Reference No:	2024/62/93539/E
Site Address:	35, Fair View, Hightown, Liversedge, WF15 6LL
Description:	Erection of front and rear dormers
Recommending Officer:	Faiza Bano

HOUSEHOLDER DELEGATED REPORT

Application Number	2024/93539
Location	35, Fair View, Hightown, Liversedge, WF15 6LL
Proposal	Erection of front and rear dormers
Publicity end date	3 rd February 2025
Number of representations received	None.
Kirklees Local Plan Allocation/Designation	LP Green Space - Strategic Green Infrastructure Network
Extension to Time (EoT)	No
Recommendation	Conditional Full Permission

Drawing Title
PROPOSED

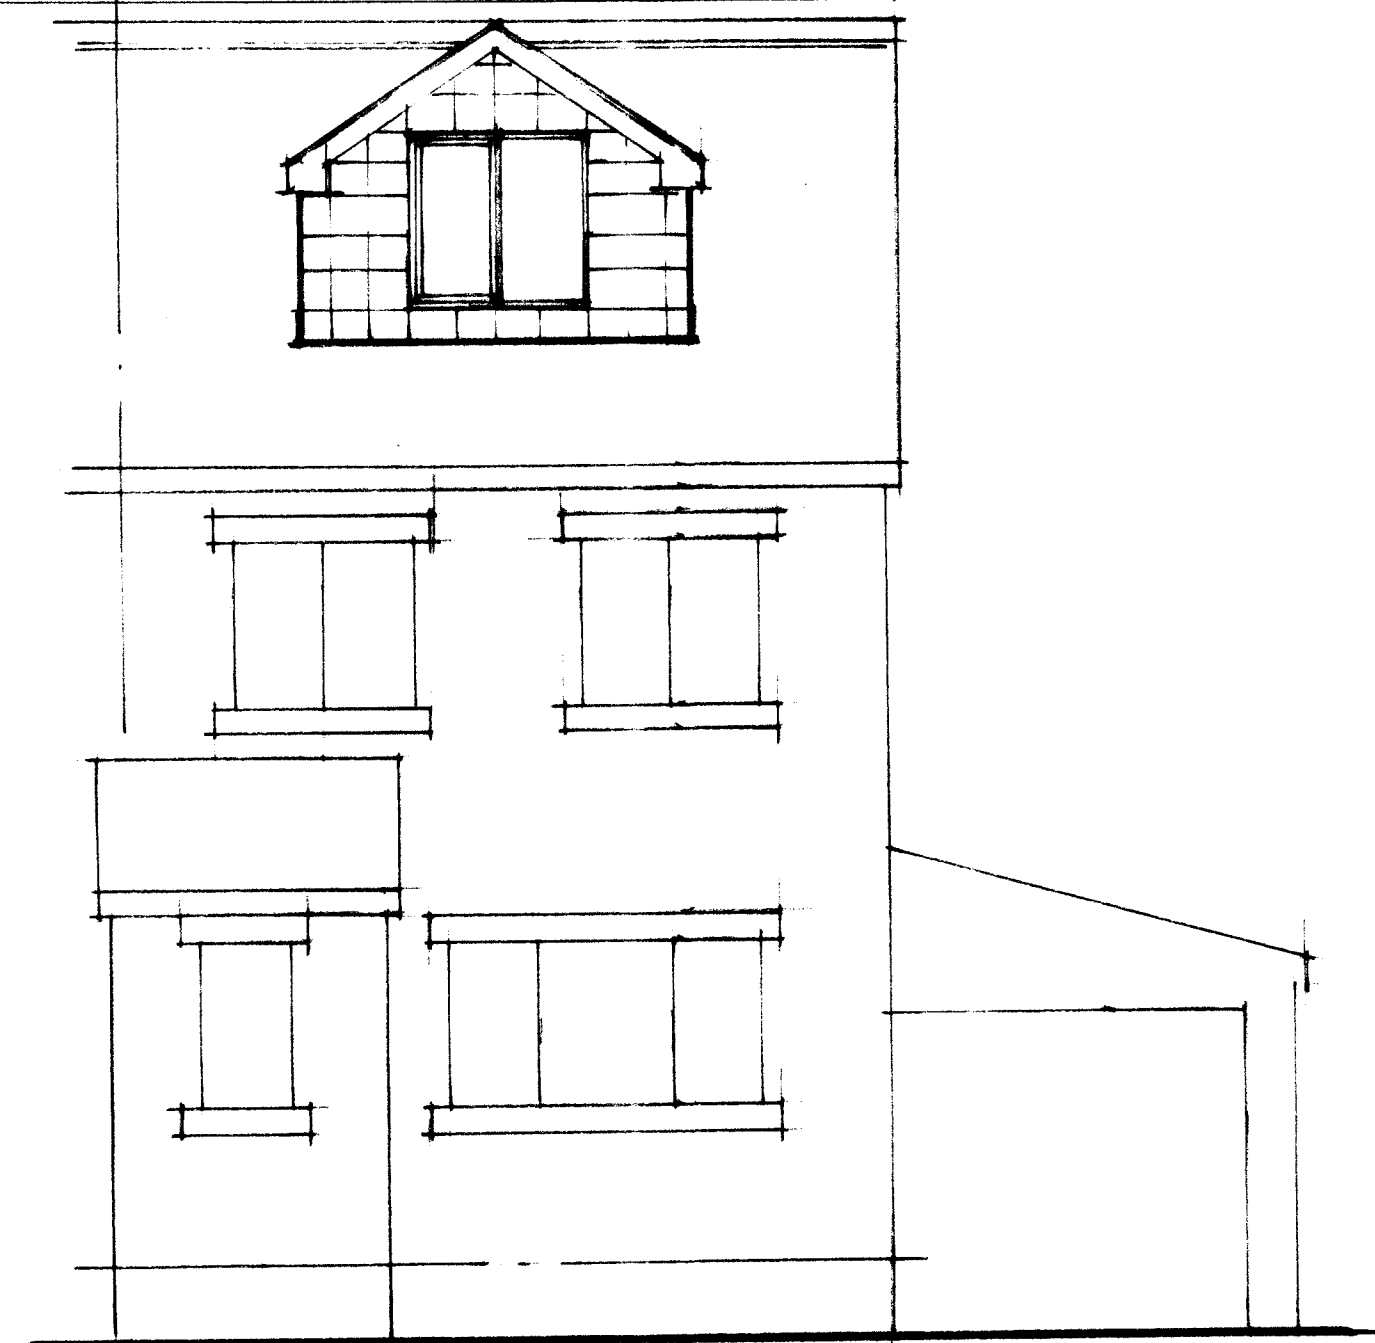
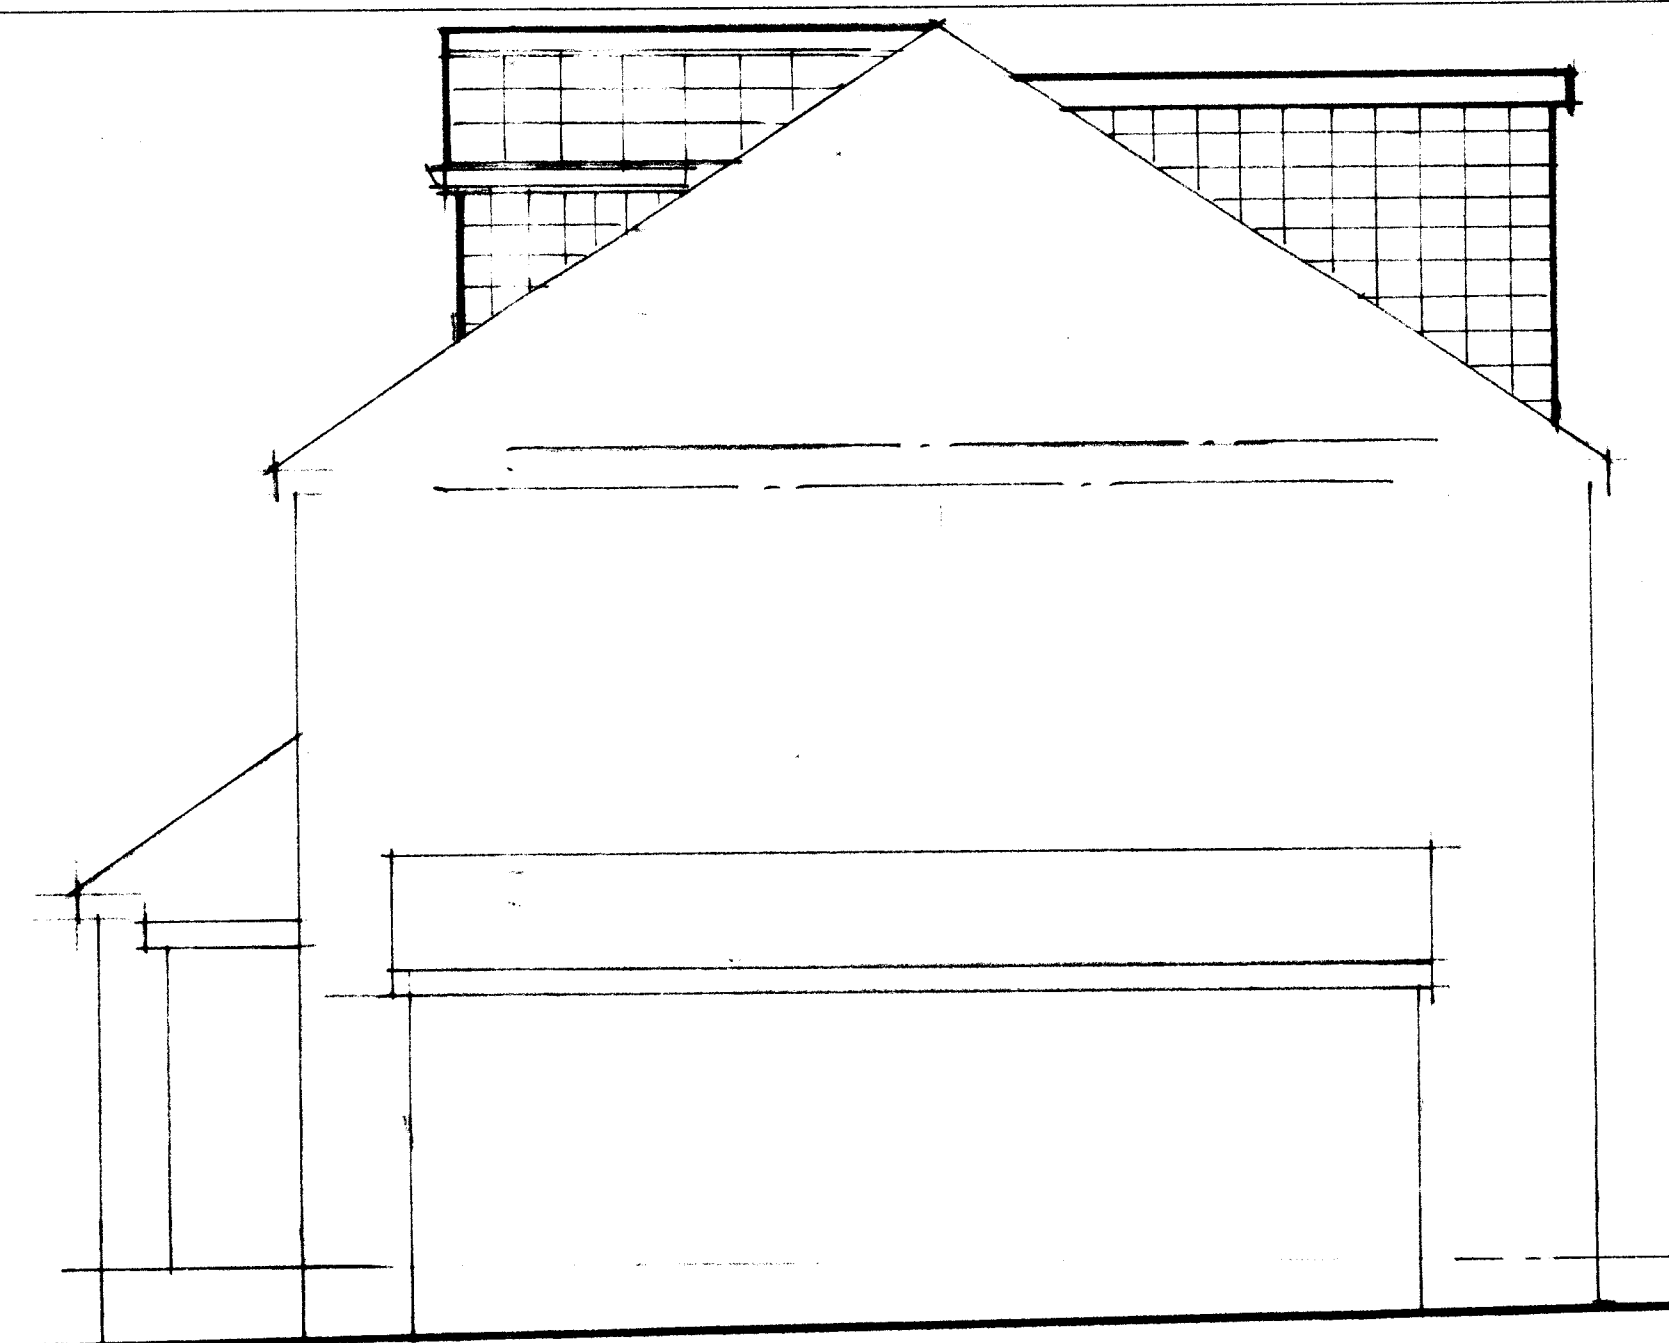
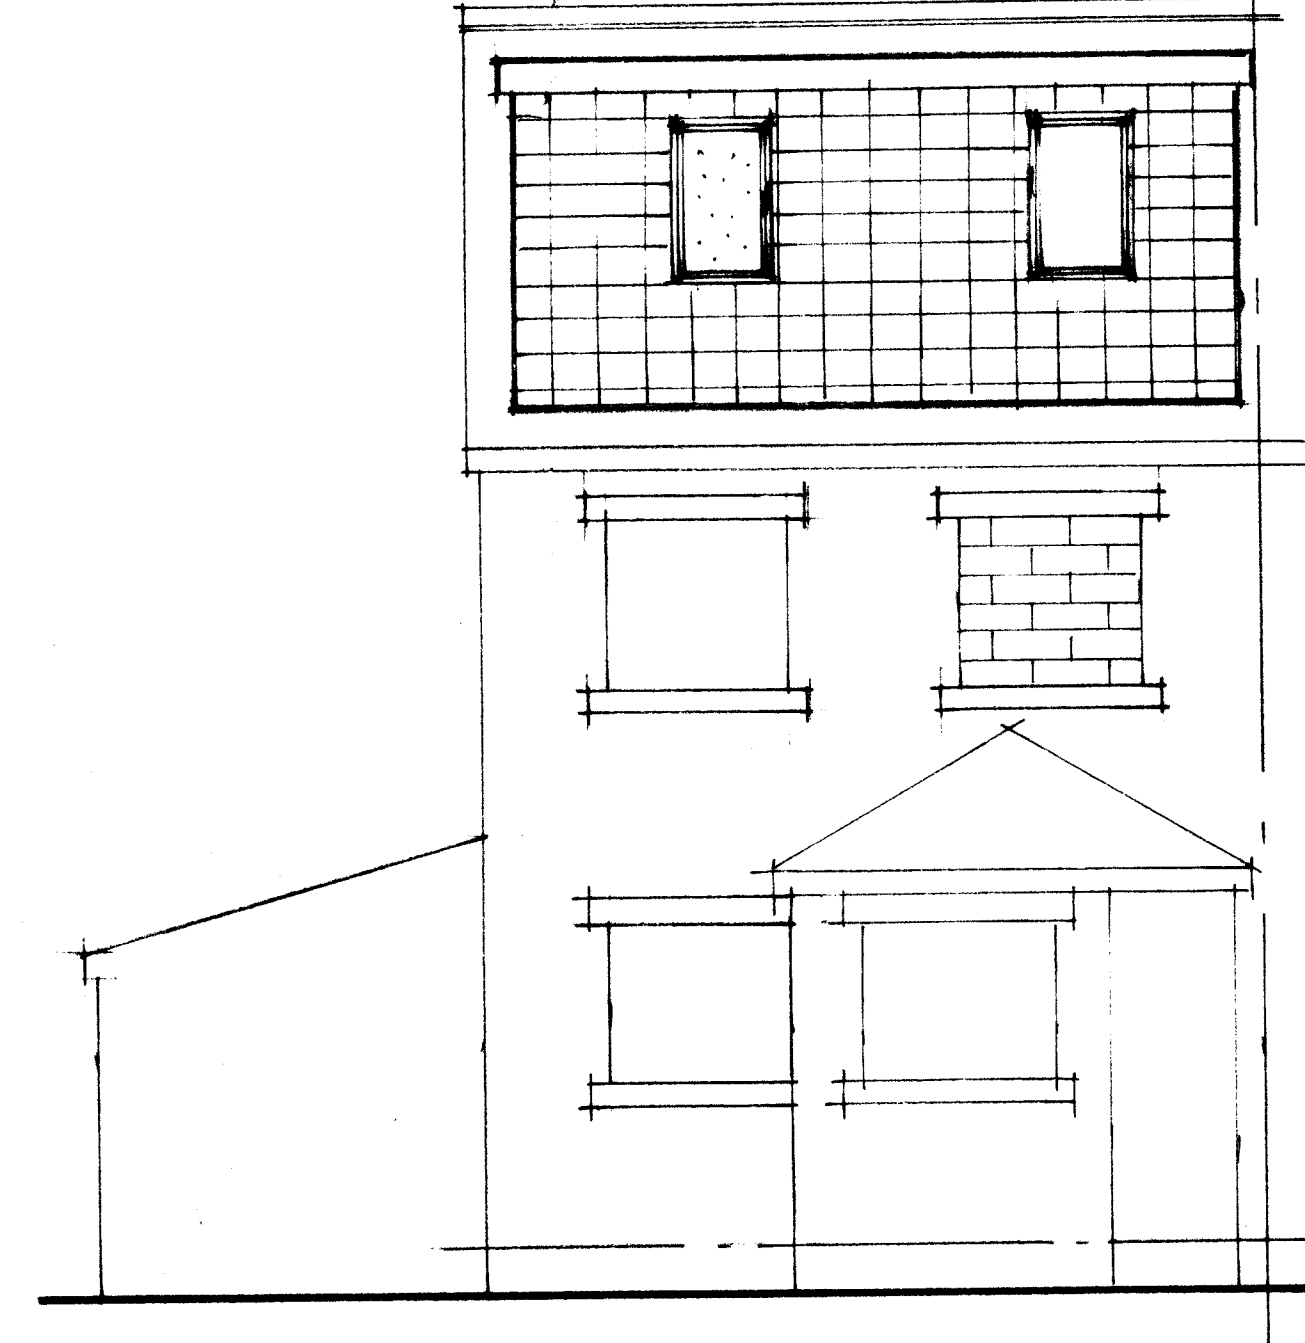
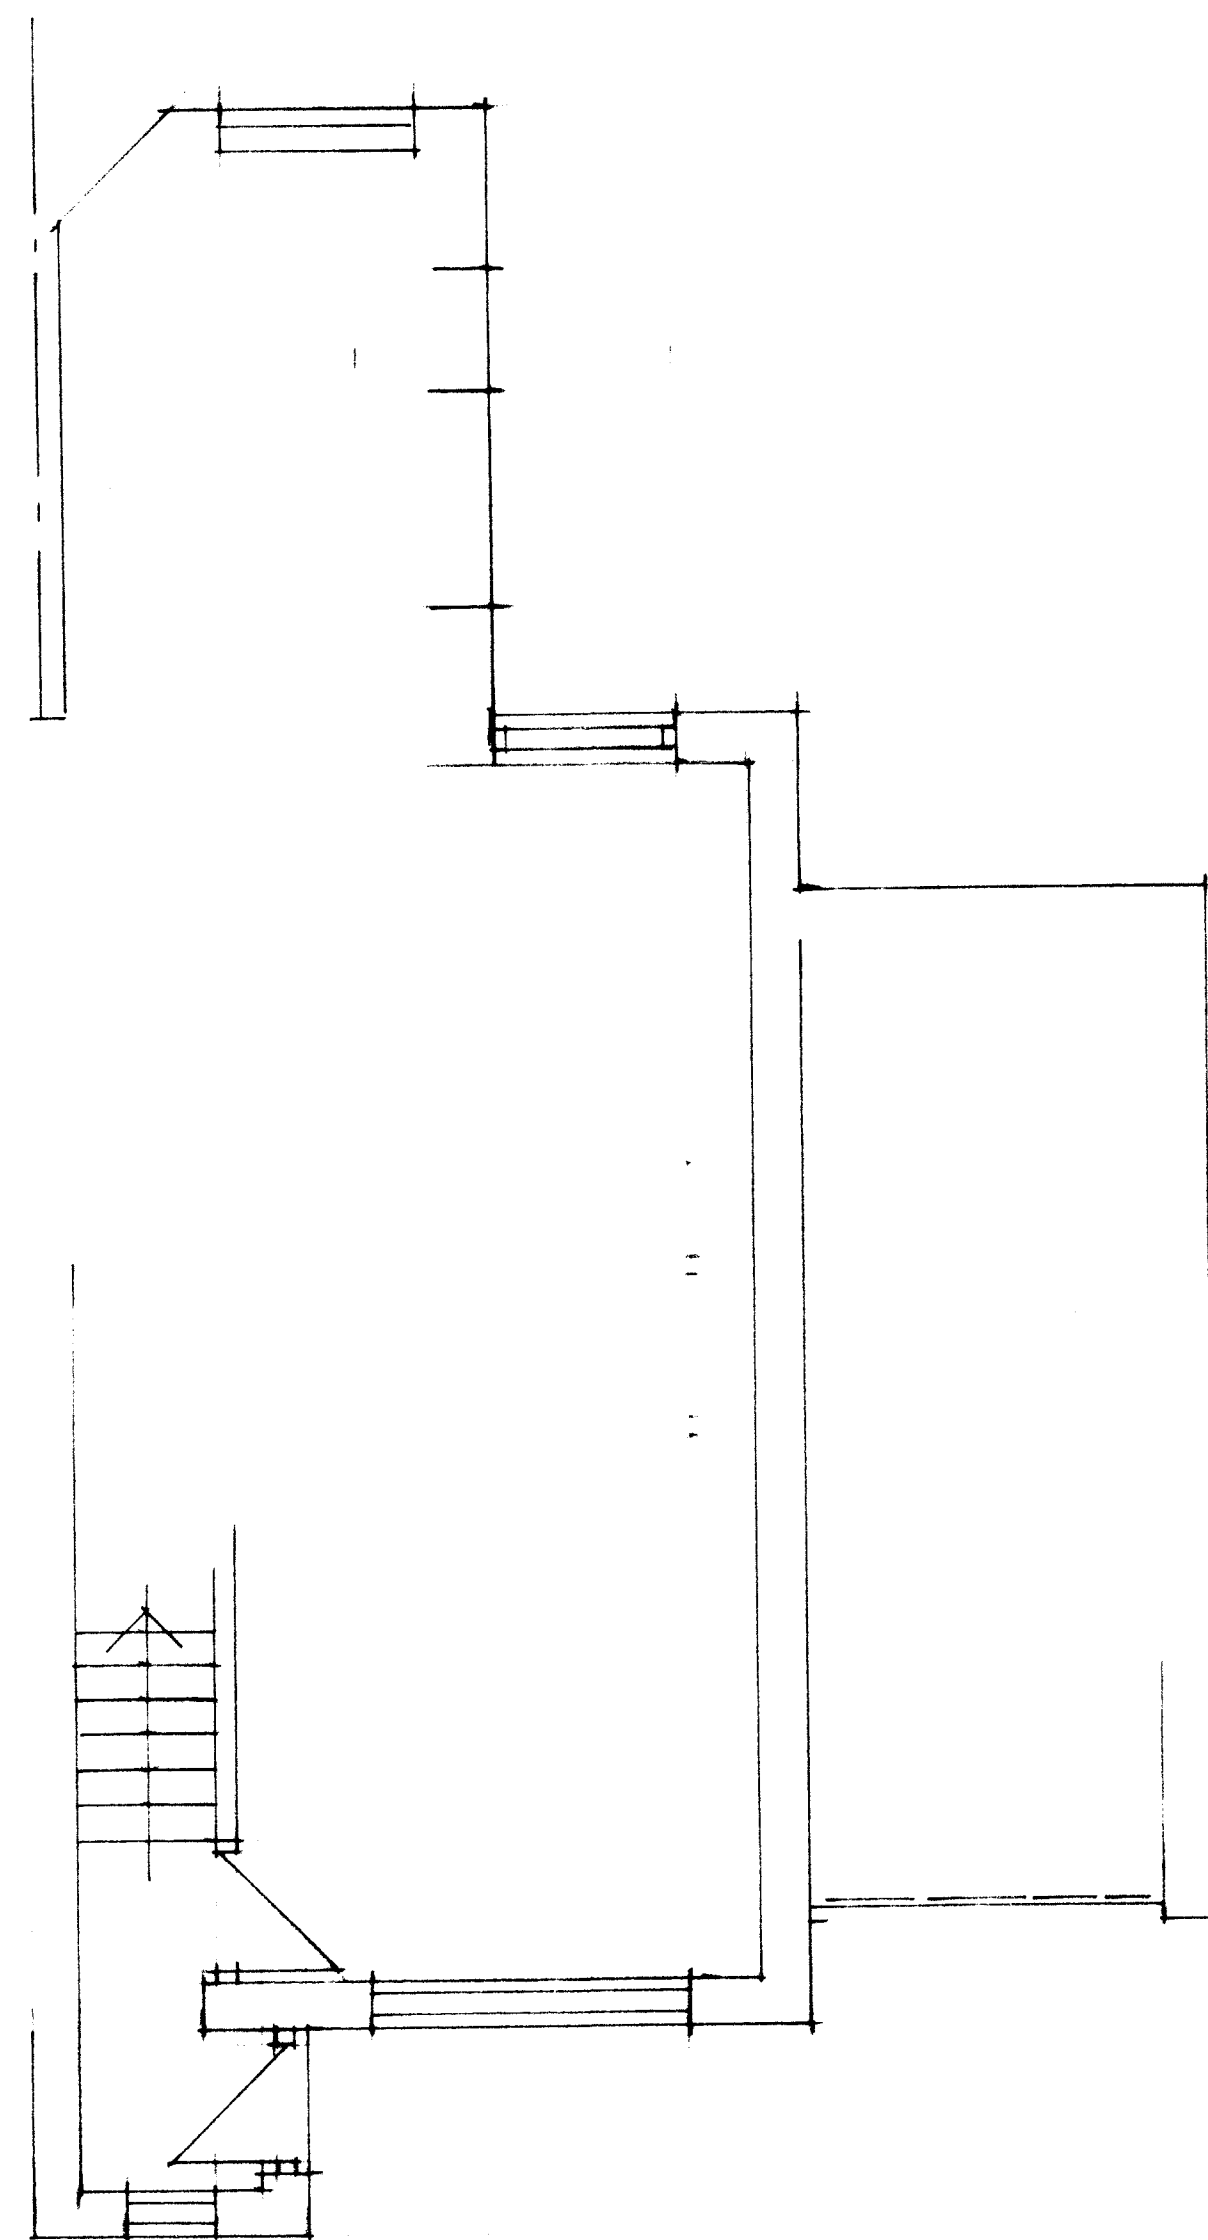
Dormer windows should:	<u>Yes - COMPLY</u>	<u>No - JUSTIFY</u>
relate to the appearance of the house and existing roof;	Yes - regarding design, the proposed dormers would demonstrate a resemblance to the original dwelling in terms of roof design.	
be designed in style and materials similar to the appearance of the existing house and roof;	Yes – dormers are designed with a pitched roof at the front and flat roof at the rear and would appear similar in terms of construction materials, design and size. The dormer is to be finished with tile.	
not dominate the roof or project above the ridge of the house;	Yes – Proposed dormers do not dominate the roof nor project above the ridge of the house.	
be set below the ridgeline of the existing roof and within the roof plane; and		The proposed dormers are set below the ridgeline and would not project above the ridge of the house. However,

the front dormer is in line with the ridge of the house. Given that the dormer has a pitched roof, officers believe that it integrates more seamlessly with the existing roof structure, creating a balanced and symmetrical appearance. If the proposed front dormer was flat roofed, it could potentially appear more prominent and less cohesive with the overall house.
be aligned with existing dormer windows on neighbouring properties in the same roof plane where relevant.		No other dormers in the area so it is considered that in this instance it is not relevant.

the Kirklees Local Plan and the NPPF		
Impact on the Local character and street scene	• KDP1 of the SPD • Policy LP24 Design (a) and (c) of the KLP • Chapter 12 NPPF	The extension is generally modest in scale and due to positioning of the applicant site, the proposed development would not appear overly prominent. The proposed development would be located to the front and rear of the property, with, and will not negatively impact the character or street scene across the frontage of the property. In terms of materiality, the dormers would be constructed using materials to match the proposed finishing of the dwelling and would be in keeping with the character of the site. In terms of the appearance and local character of the street scene, the proposed extension is considered acceptable.	✓
Impact on original house	• KDP2 of the SPD • Policy LP24 Design (c) and (d) of the KLP • Chapter 12 of the NPPF	The original property would remain the dominant feature. The addition of the dormer will add an aesthetic appeal and practical benefits to the house, providing extra space, light and ventilation around the house.	✓

Height, scale and massing	• KDP 1 and 2 of the SPD • Policy LP24 Design (a), (c) and (d) of the KLP	The extension would project across the front of the property.	✓

- The front dormers are unlikely to cause any significant harm in terms of residential amenity of the adjoining properties given the level at which the works would be sited. The sloped nature of the applicant site and the position within the existing roof is such that there would be no overshadowing.
- Having considered the above factors, the proposals are not considered to result in any adverse impact upon the residential amenity of any surrounding neighbouring occupants.
- There are no properties immediately to the front or rear of the application site.
